Application for Planning Permission

Development: Erection of a 3-storey building comprising of under-croft car parking and bicycle store, 2 floors of 4 No self-contained flats on each (8 No flats in total) with pedestrian access formed onto Ash Grove. This application is in CIL Zone 4 (Zero Rated) as flats.

Location: Land East Of Heath Place Bersted PO22 9SL

Location Plan
1:1250

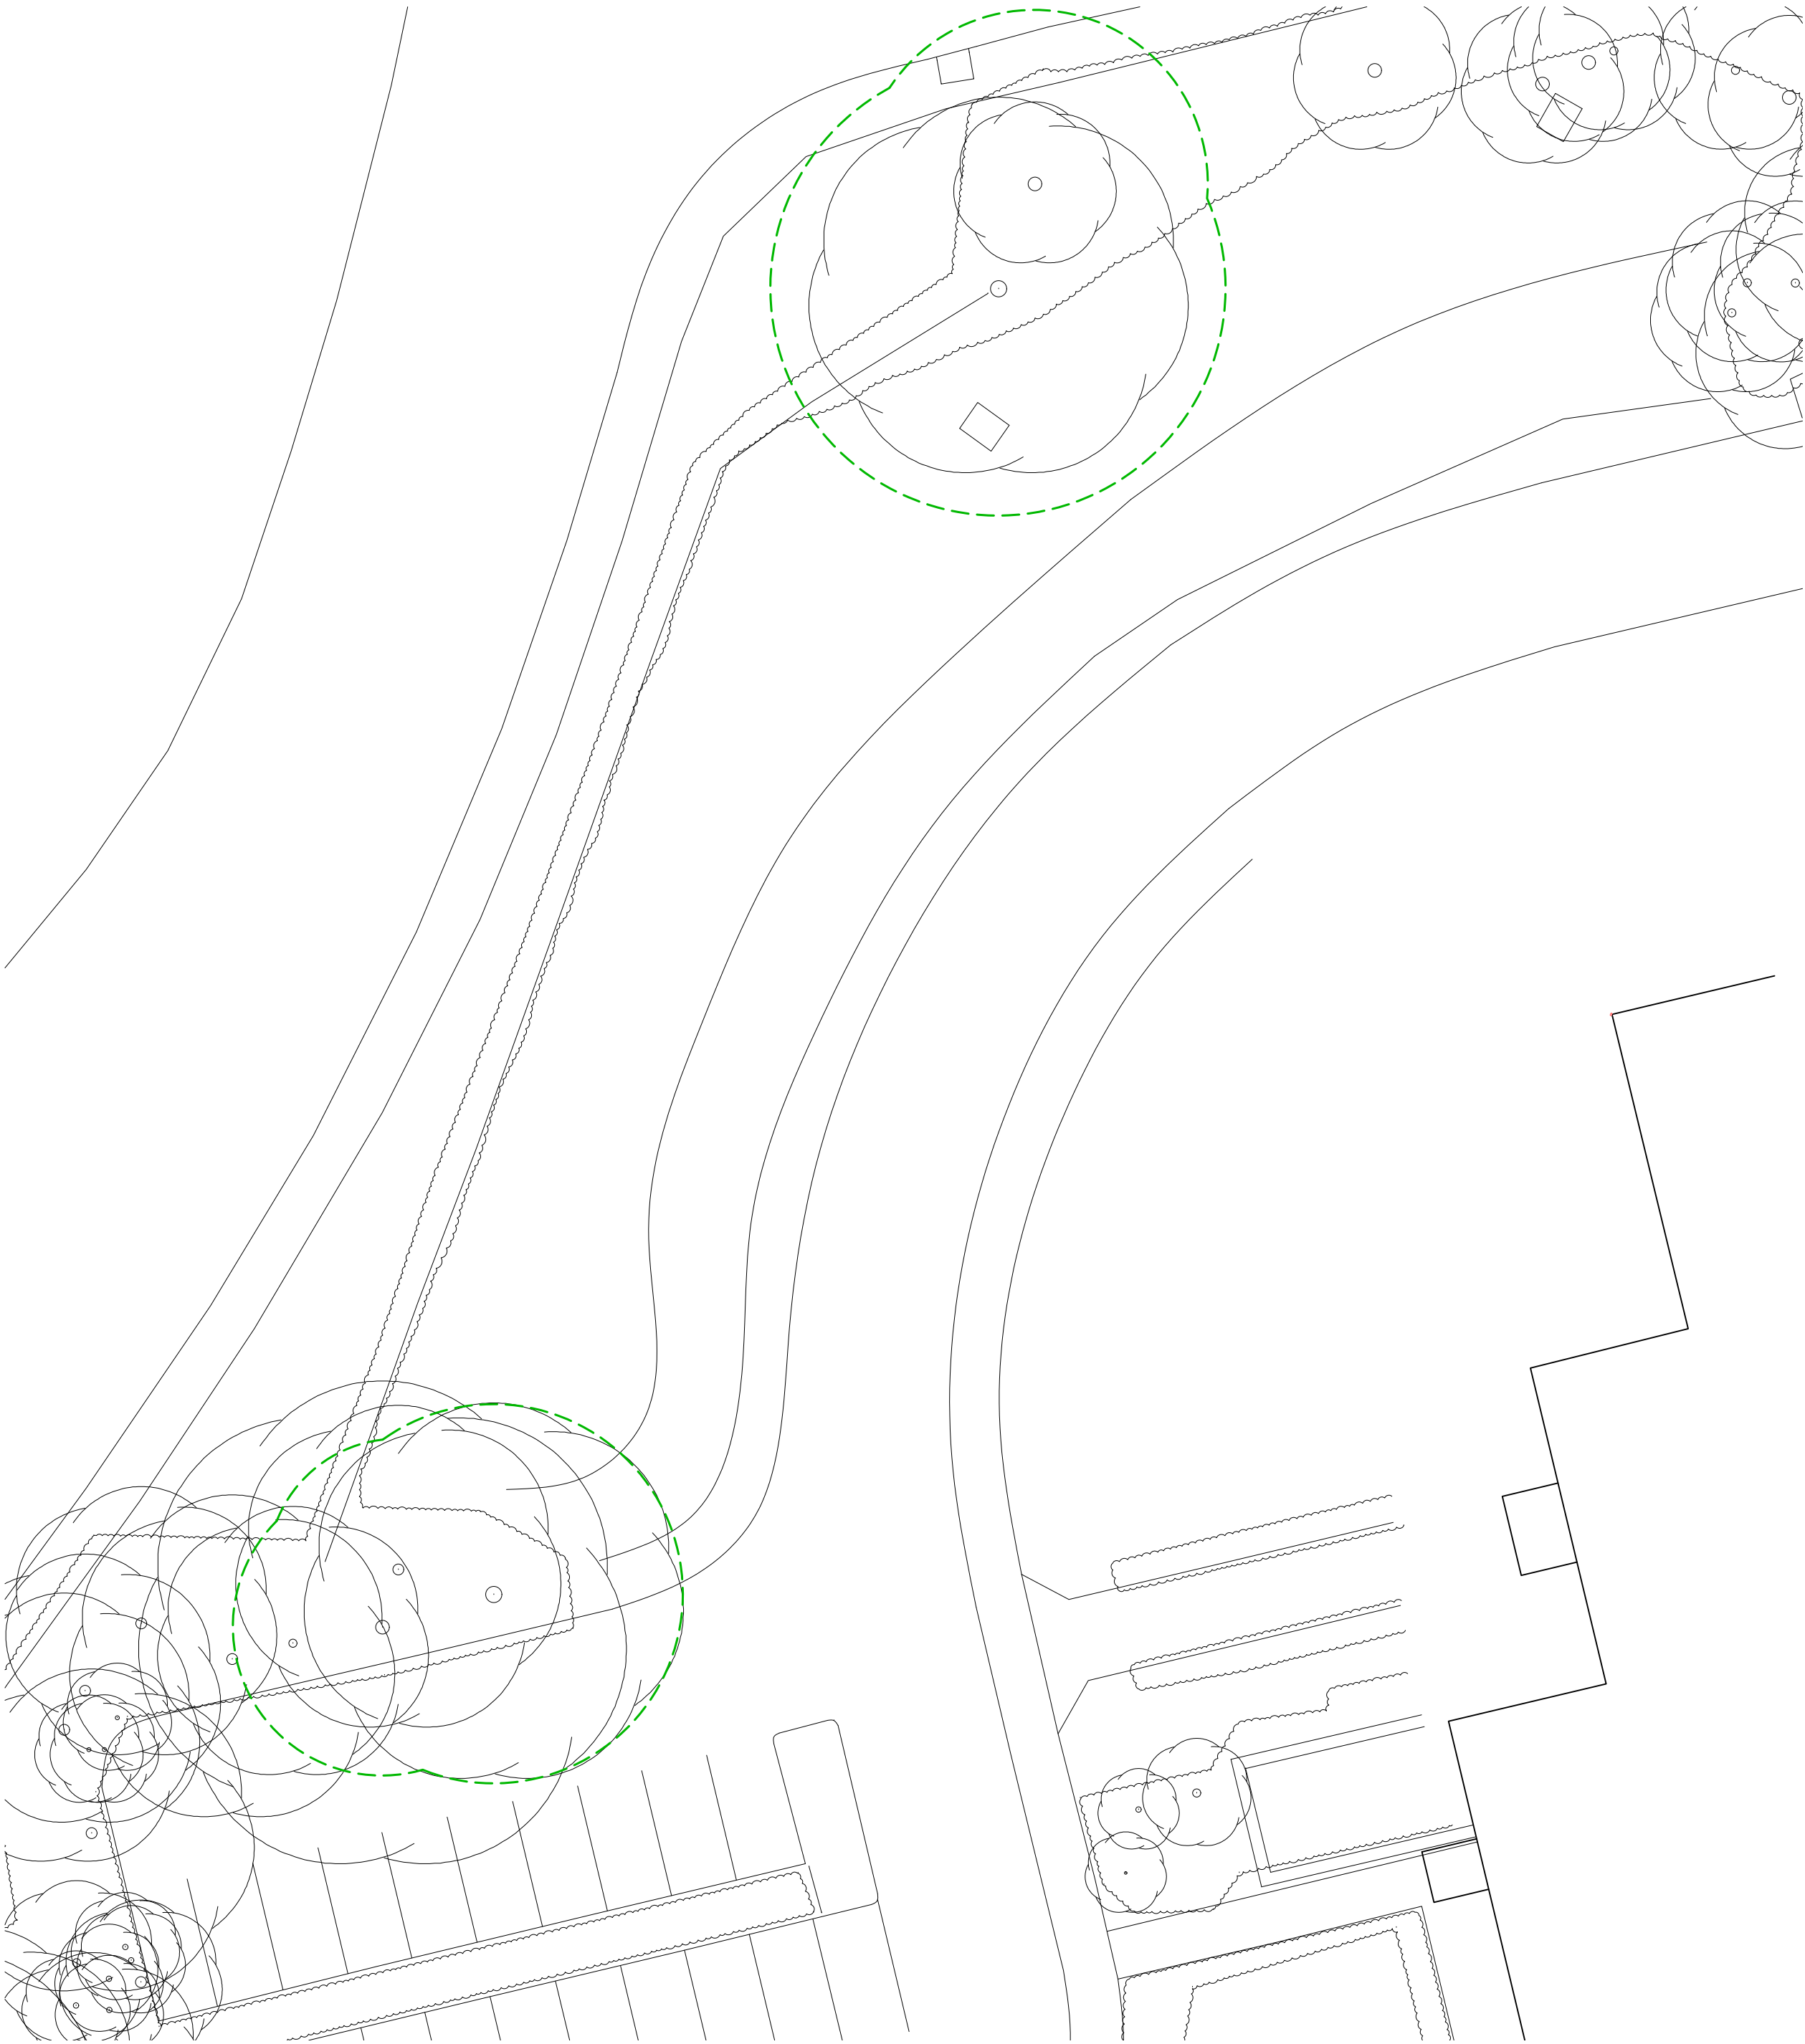
Please provide a full blue edge.

Proposed Site Plan
1:200

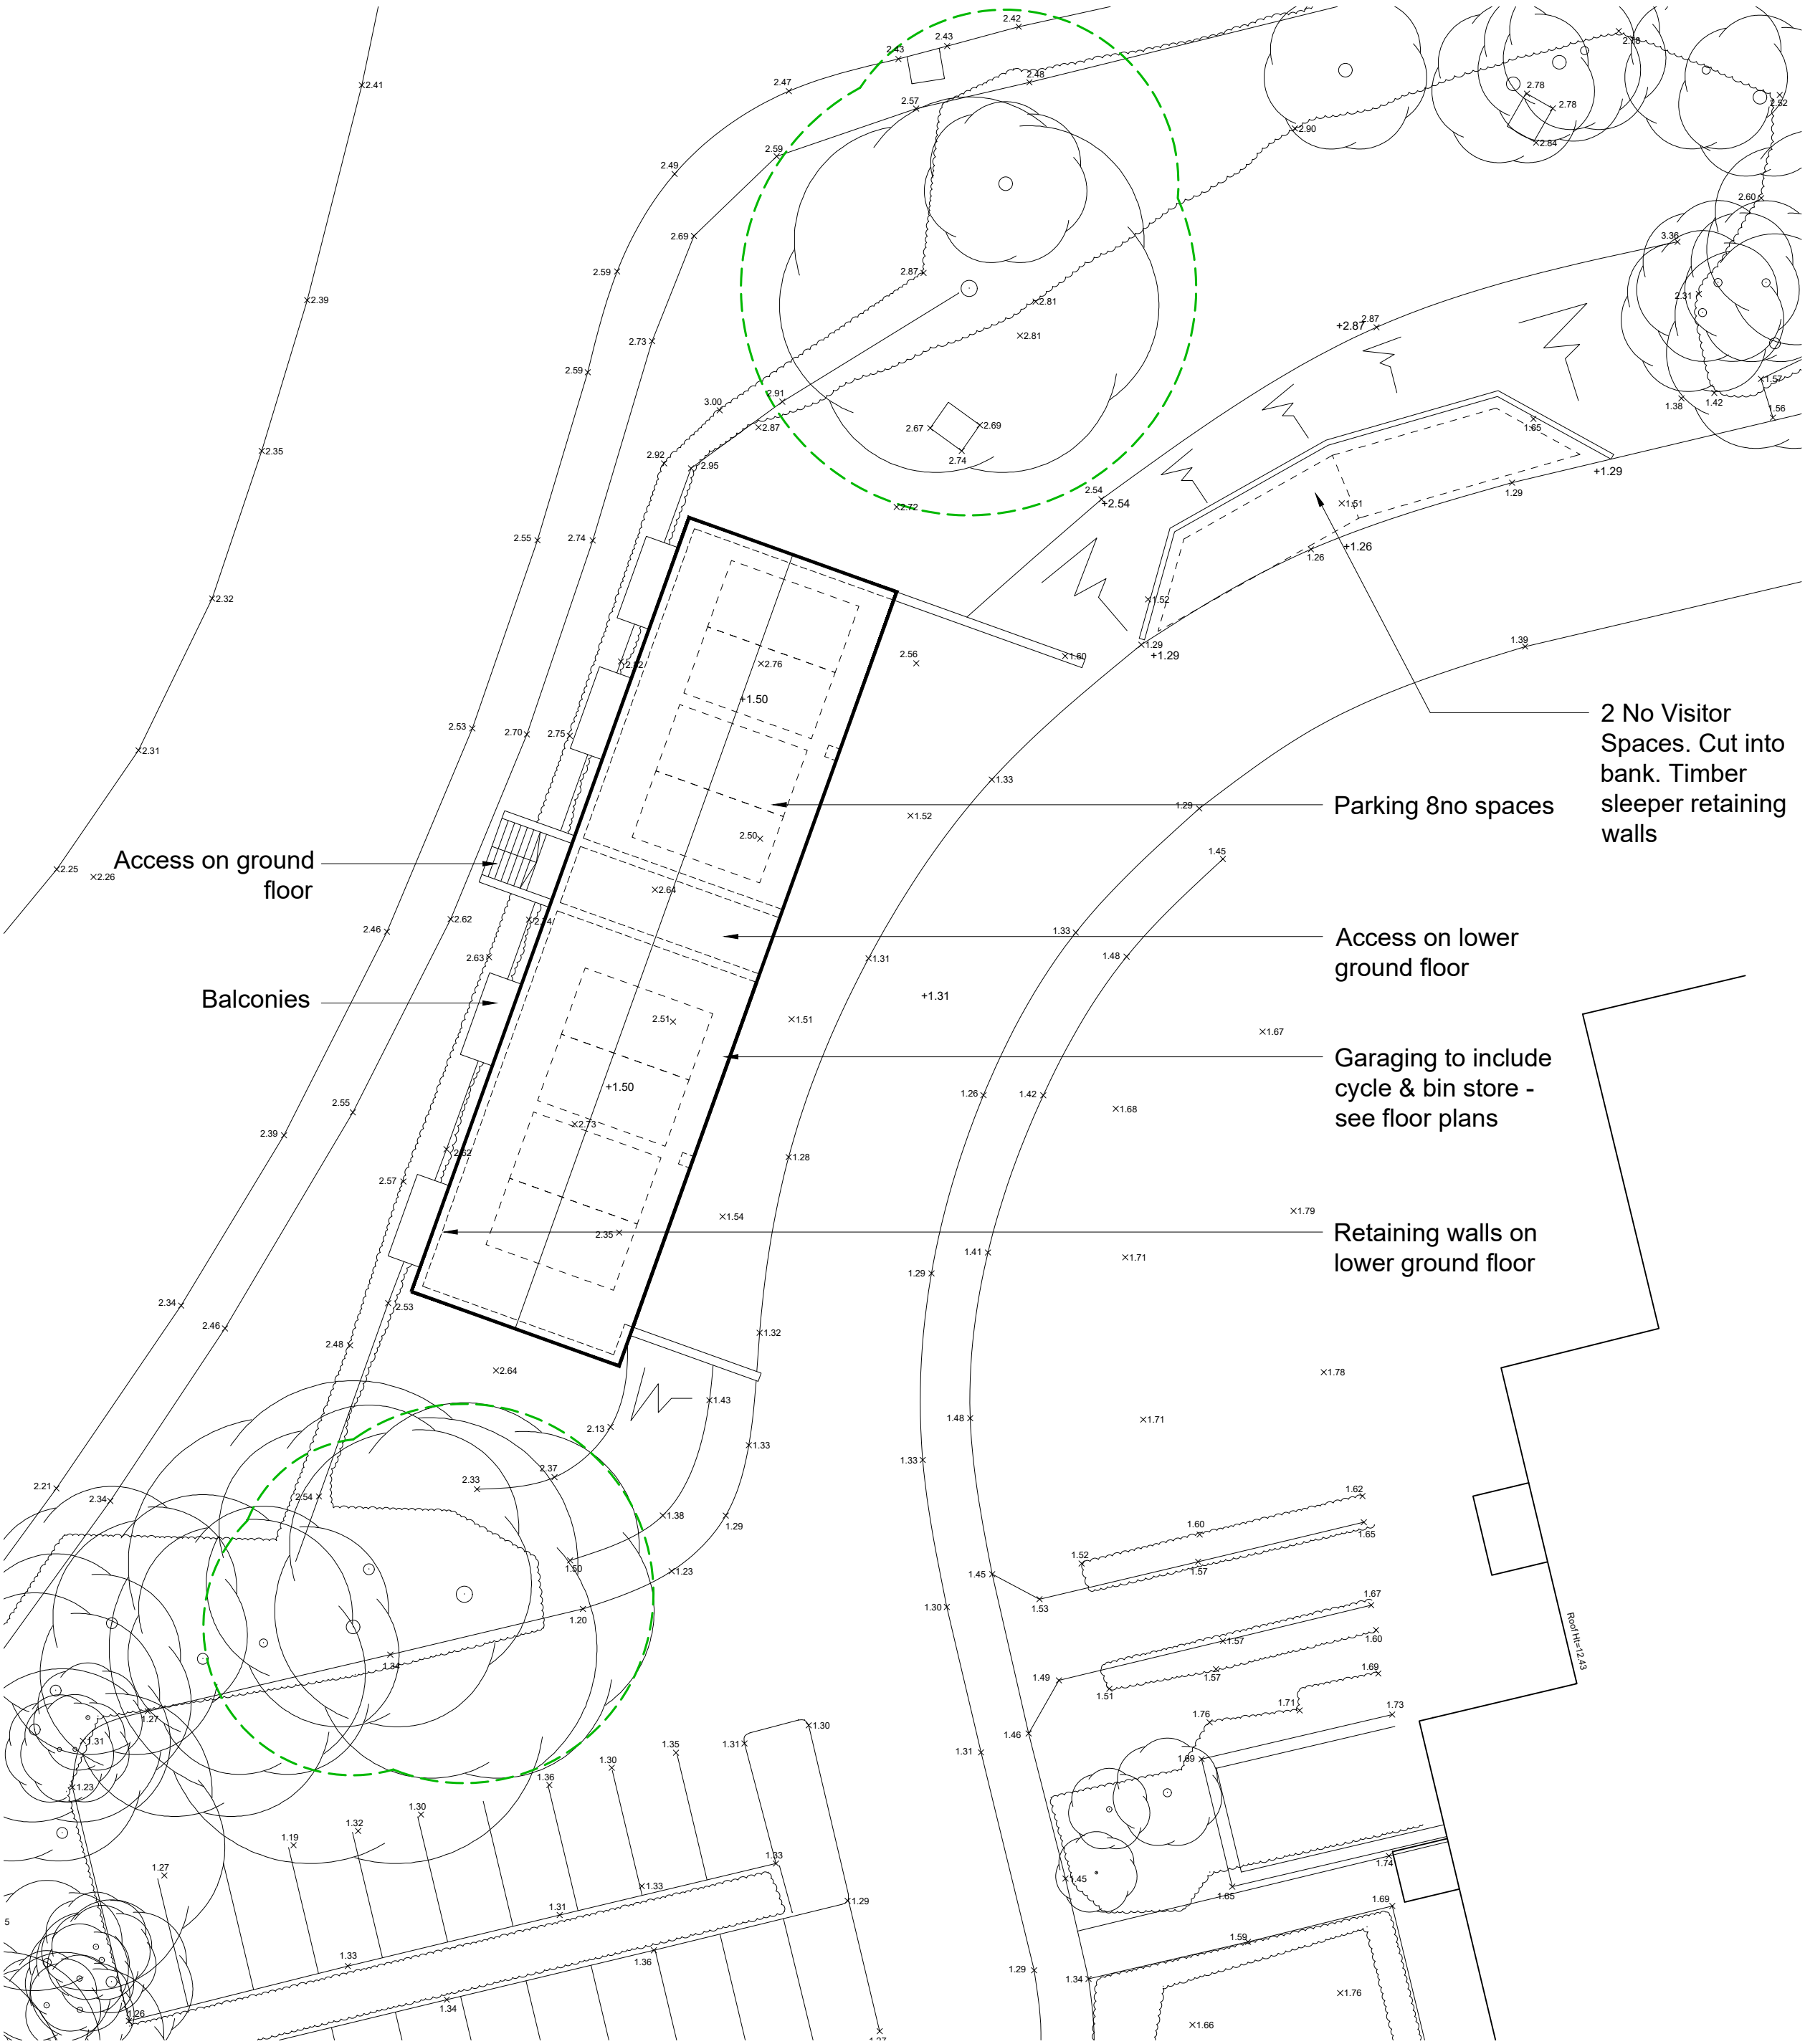
The application form states this proposal includes a new vehicle access from the highway. Please show the proposed access and visibility splays on the proposed site plan.
